DoP Comment 1:

The traffic assessment in the Engineering Services Report (Attachment 3), should also provide an assessment in accordance with the RMS's Guide to Traffic Generating Development rather than only the rates identified in Councils Contribution Plan.

BULK EARTHWORKS SECTION - SECTION B

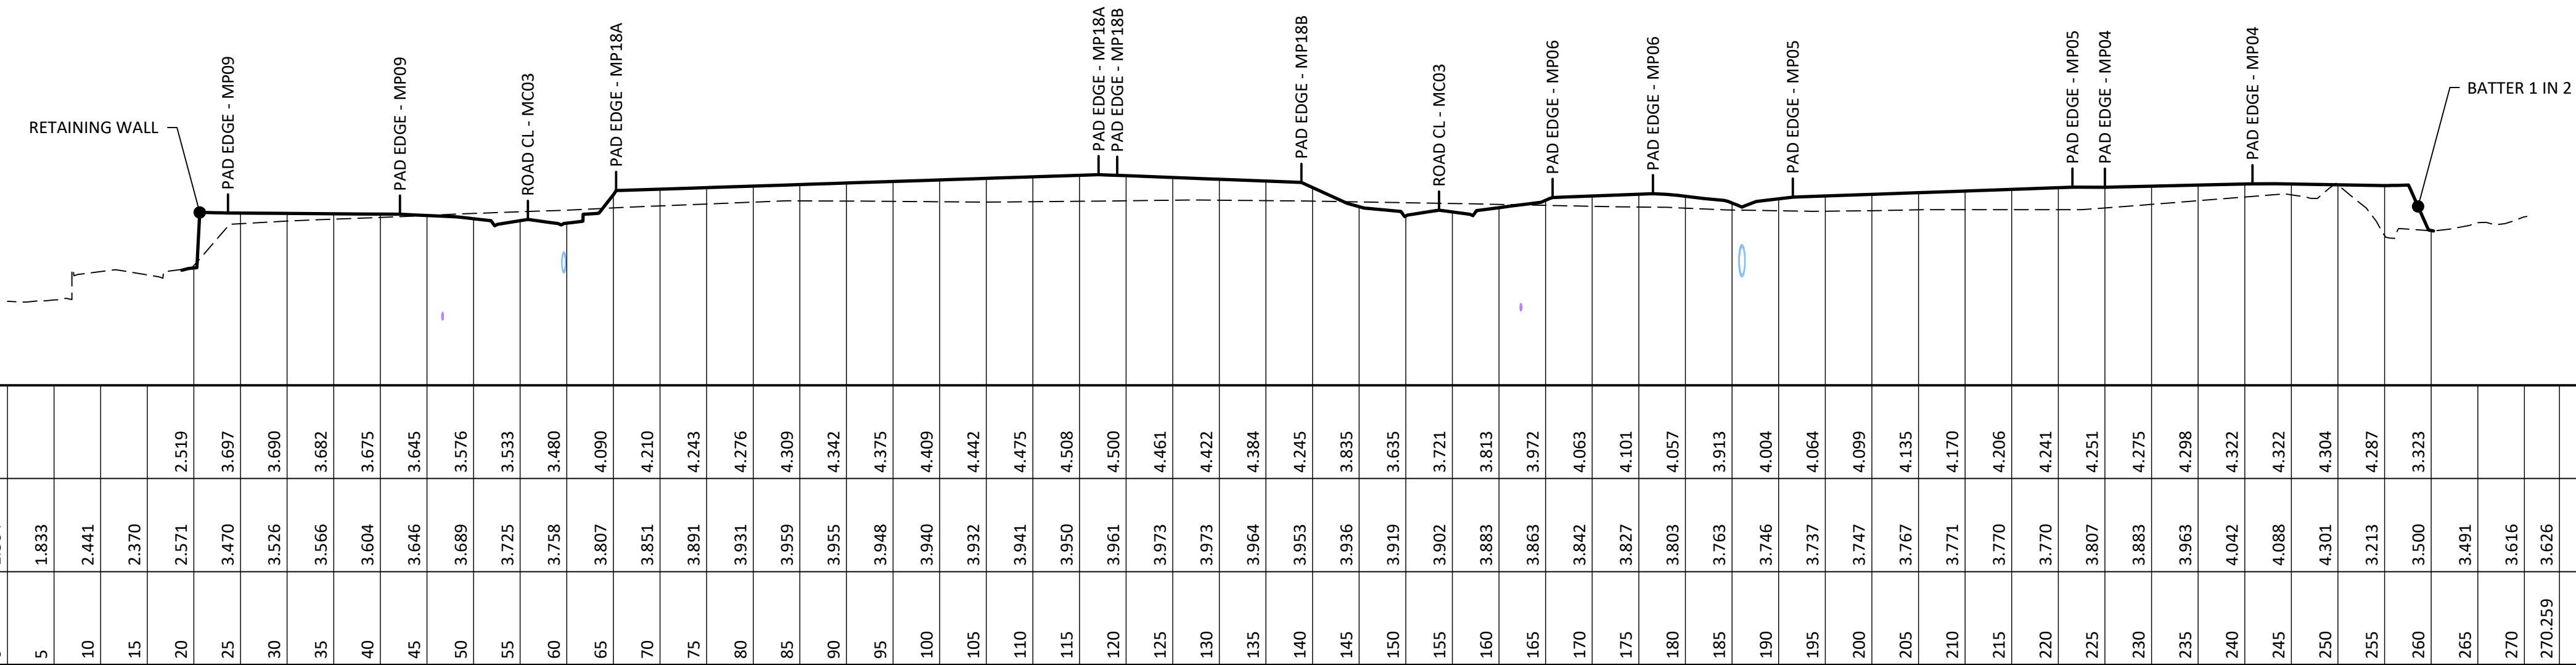
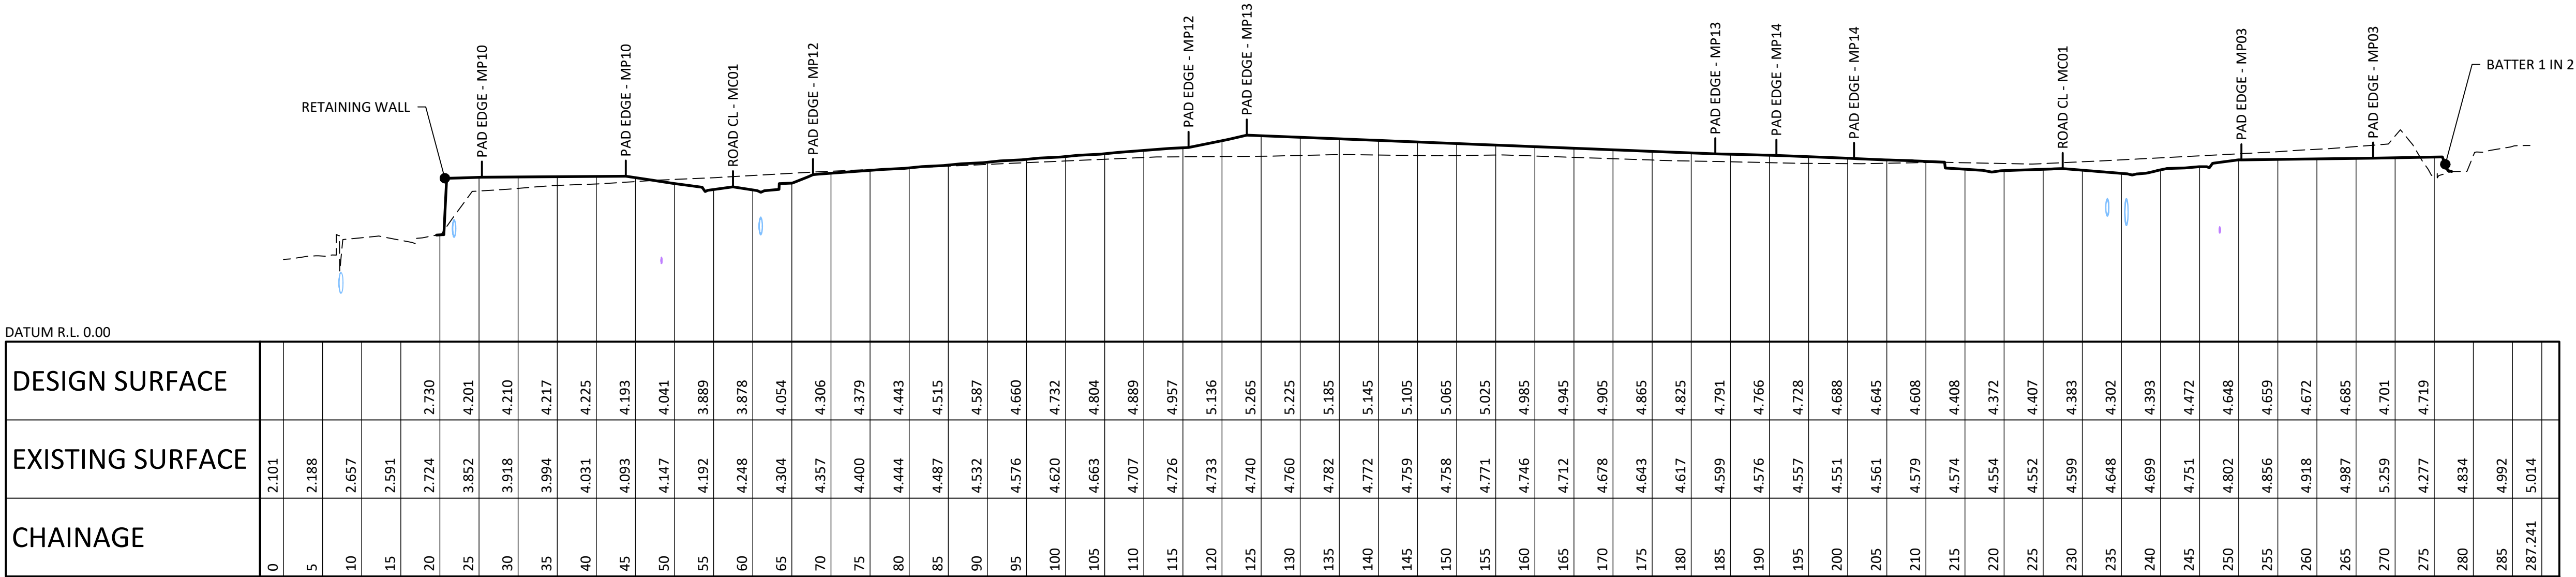
Identify the final ground levels for the Super Lot 5 subdivision and assess the impact of these levels on future development within the site

The final ground levels of the site have been shown on the BE series engineering plans attached to the Engineering Services Report. The ground levels have been based on the proposed development footprint of the site (for example pads provided for each set of buildings). The ground levels across the site are detailed on the Bulk Earthworks Sections provided.

EPIQ ESTATE - LENNOX HEAD, NSW, 2478 SUPER LOT 5 CIVIL WORKS LONGITUDINAL SECTION - MC04		
Reference No. 2014/351	DRAWING No. 14351-S5-DA-CI-14	REVISION B

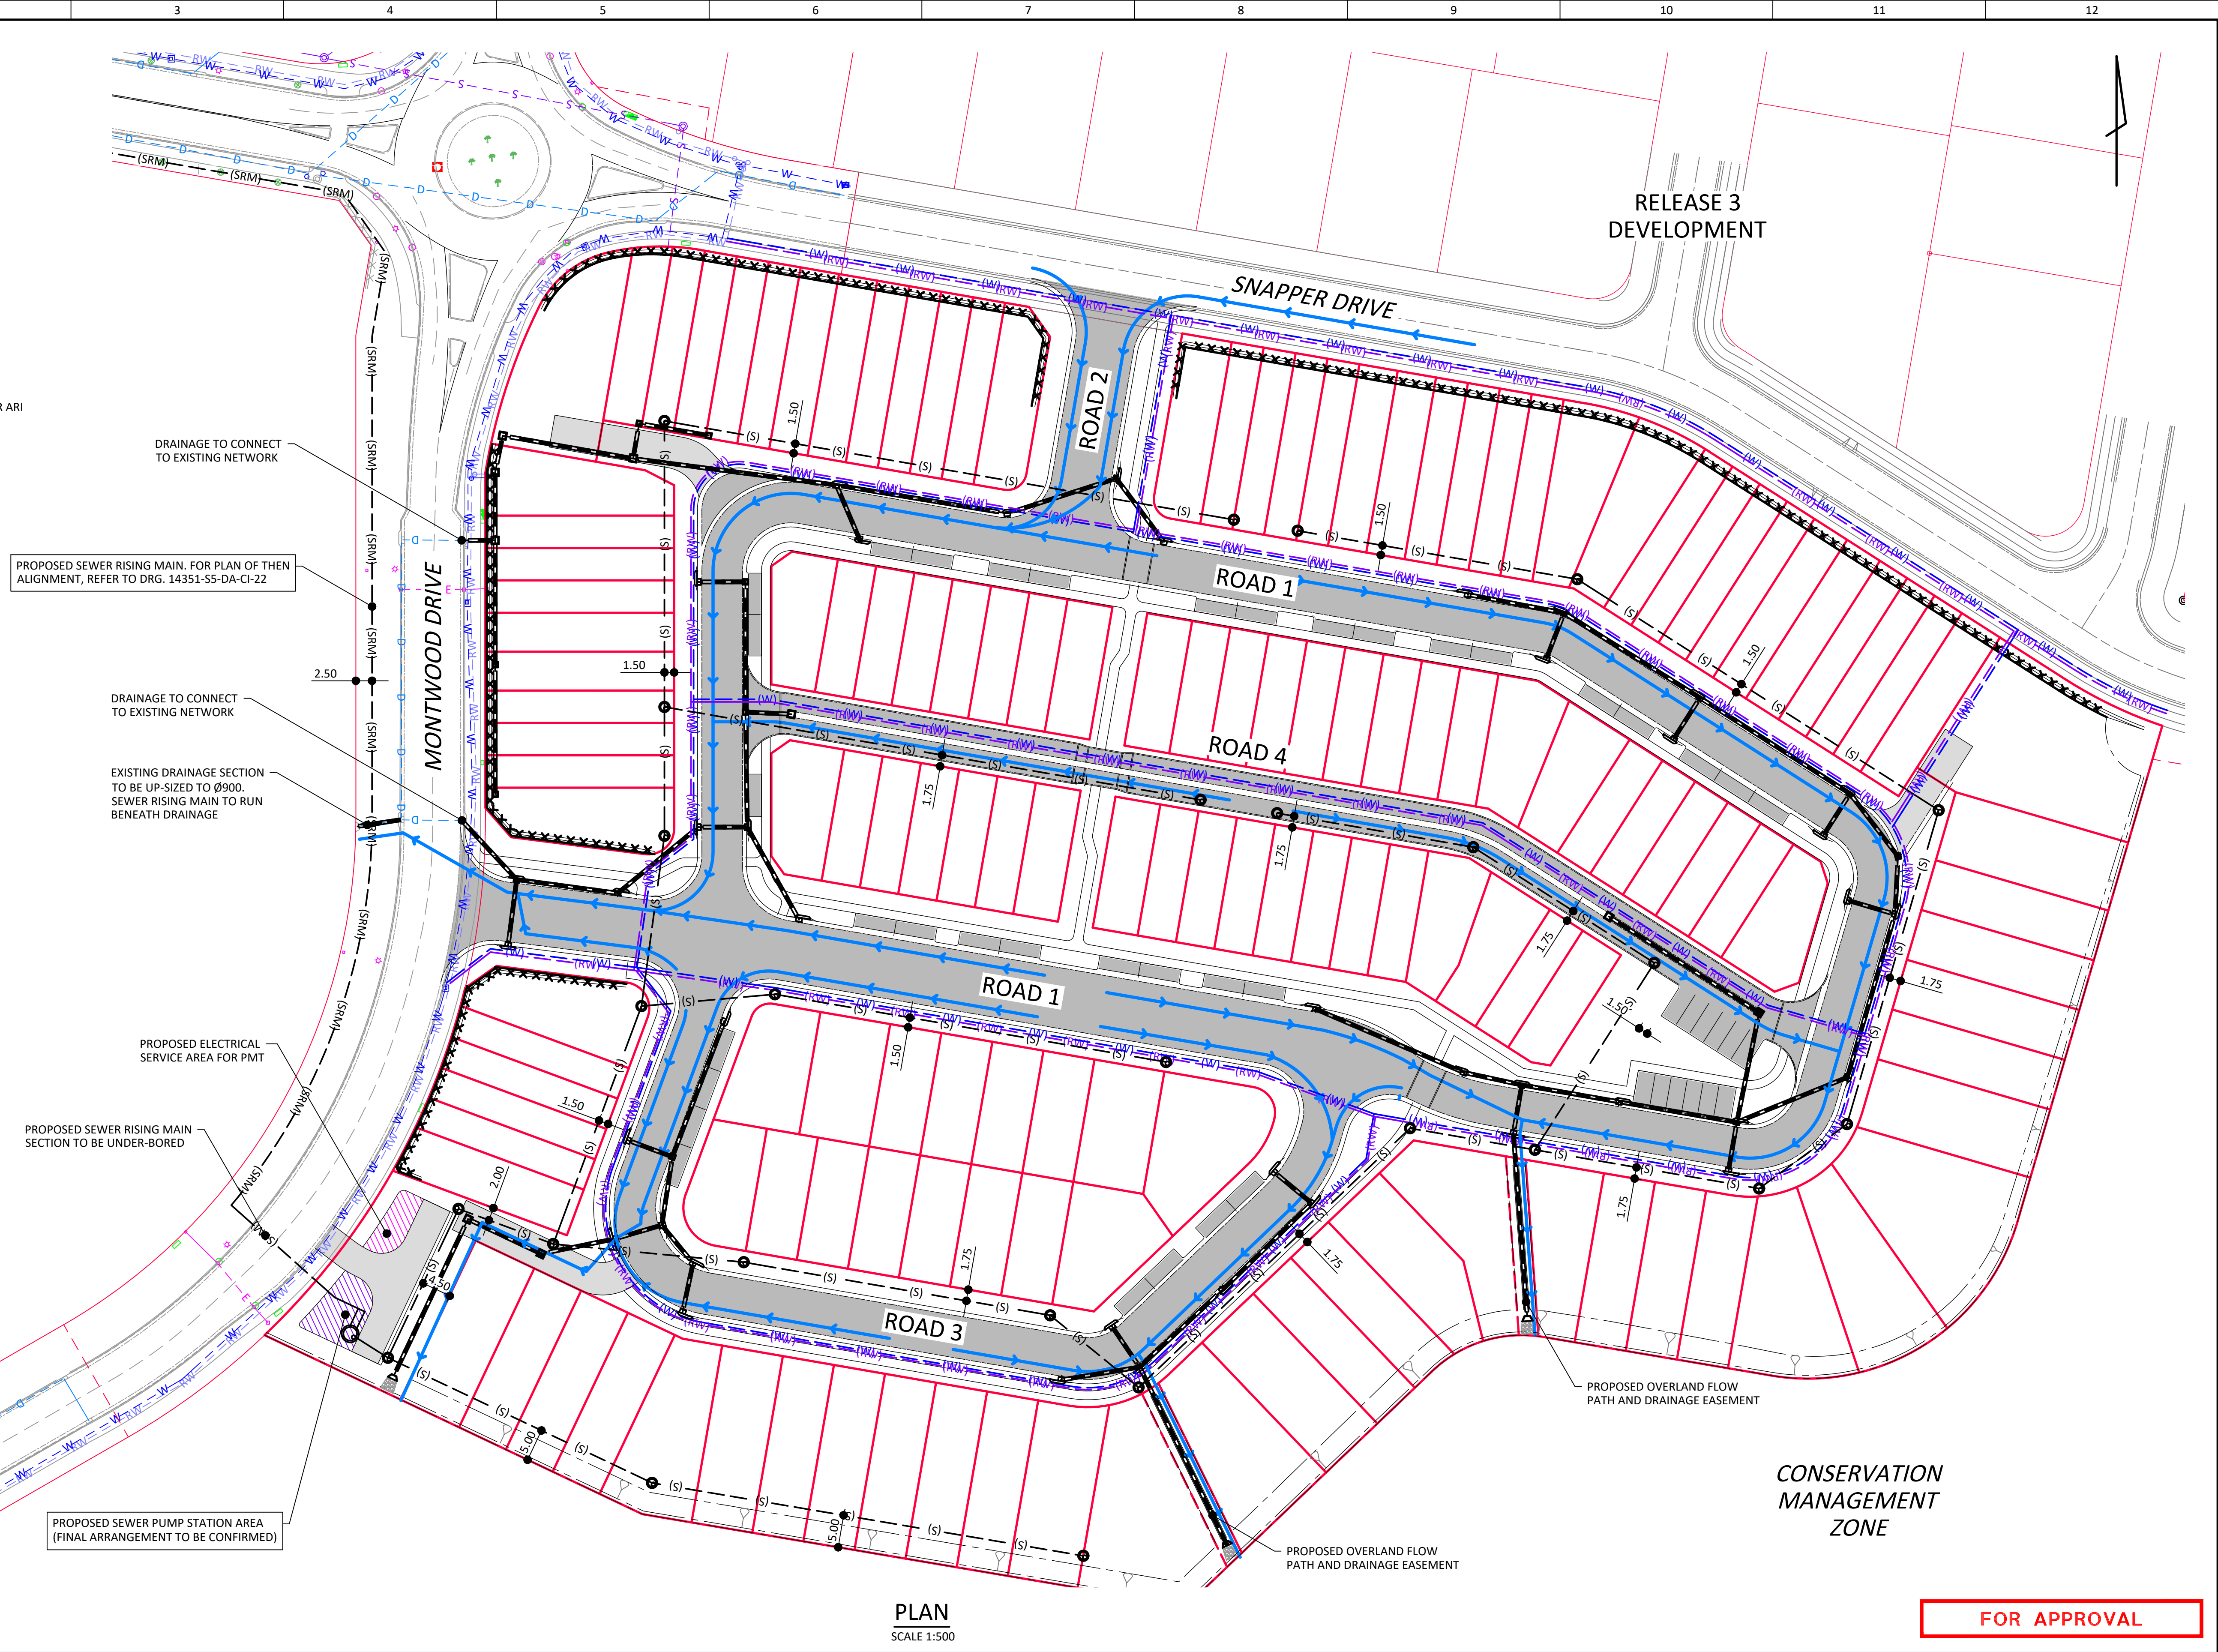
Confirmation from a suitably qualified person that there will be no additional flooding impacts than those already assessed.

Phone discussions reveal that this comment relates to the flooding of upstream properties caused by filling above the minimum heights specified in the approval. The minimum height specified must be exceeded to provide stormwater drainage across the site (ie the site needs some grade).

The only adjacent residential lots are associated with Release 3 of the Epiq Estate (currently under construction). This stage is to the north of Snapper Drive. Snapper Drive generally sits above the final SL5 site by at least 1m. As the Release 3 lots are significantly higher than the proposed SL5 site no adverse affects on these lots are expected. An overland flow path through SL5 has been provided for upstream catchments.

EPIQ ESTATE - LENNOX HEAD, NSW, 2478
SUPER LOT 5
CIVIL SERVICES
PLAN

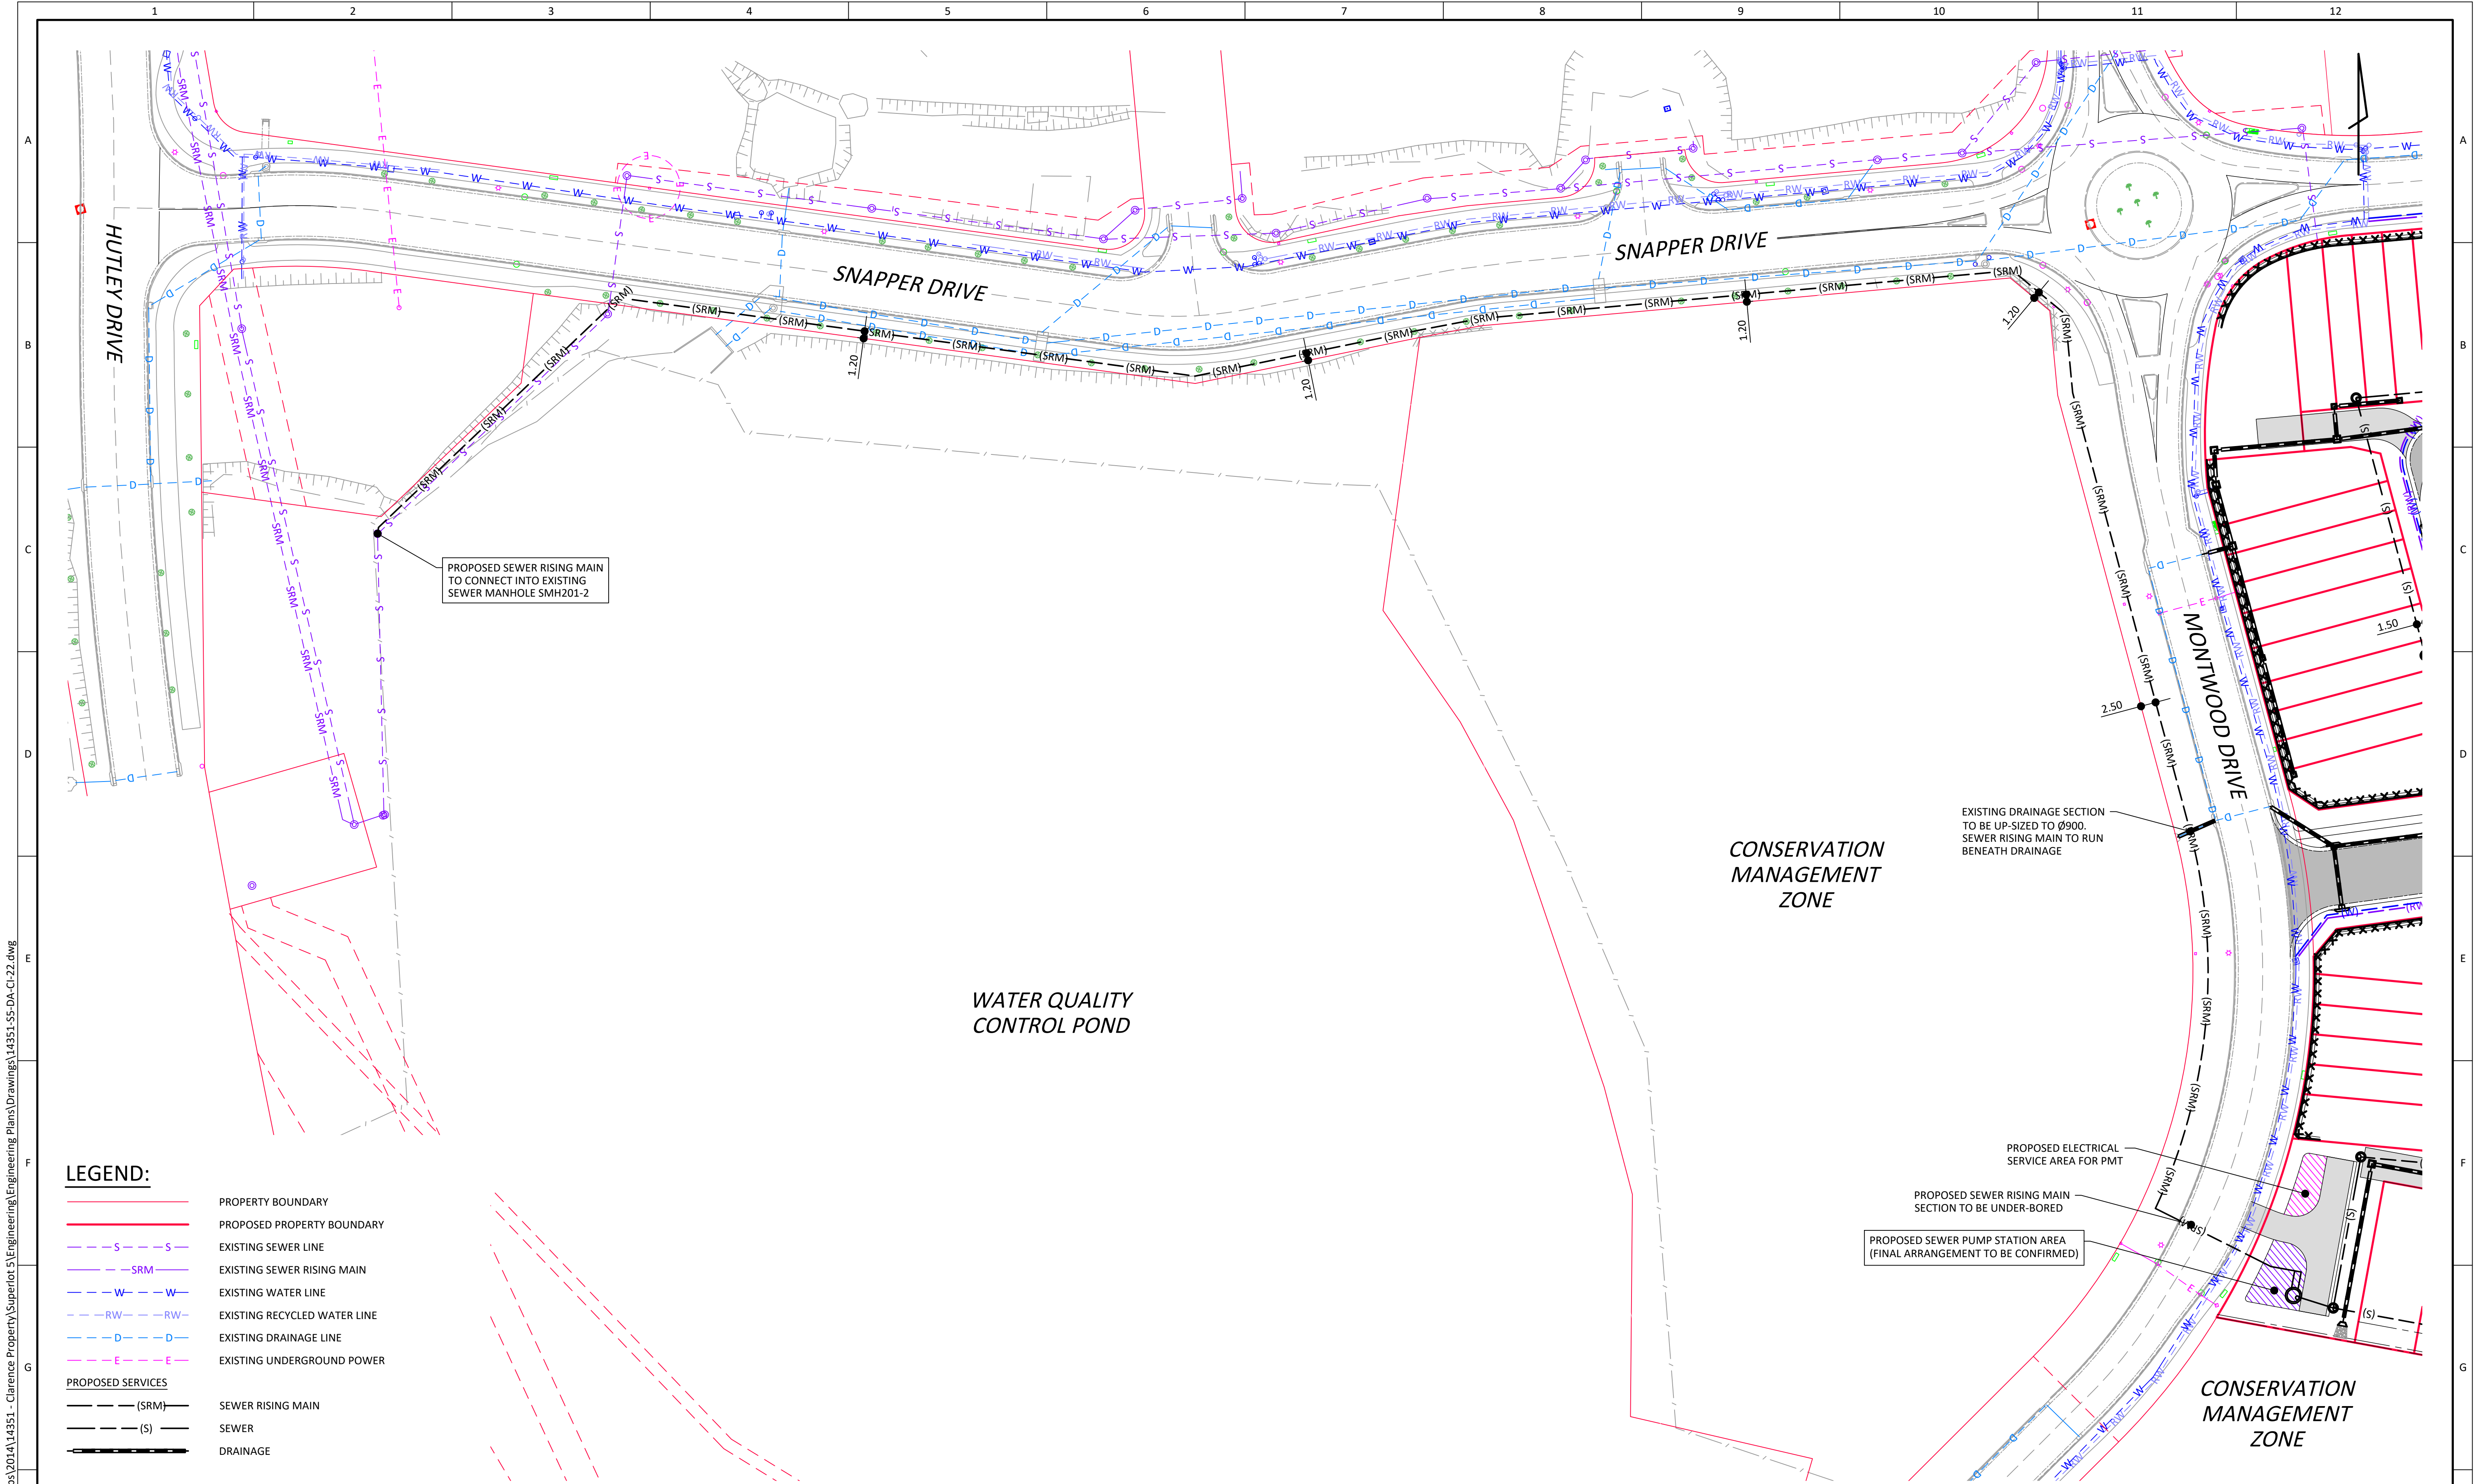
The Engineering Services Report (Attachment 3) indicates that all lots will be connected to sewer and water connections however doesn't discuss whether the existing infrastructure has the capacity to accommodate the additional connections. Please clarify whether the existing utility services have the required capacity to accommodate the dwellings.

The downstream sewer capacity has been considered and analysed by Willow + Sparrow Engineering. This report was attached to Appendix E of the Engineering Services Report and identified the connection point to the downstream network at a point where there is sufficient capacity.

The capacity of the surrounding Potable and Recycled water networks has been Modelled by H2One. This report has been attached in Appendix F and is referenced in sections 9.1 and 9.2 of the engineering services report.
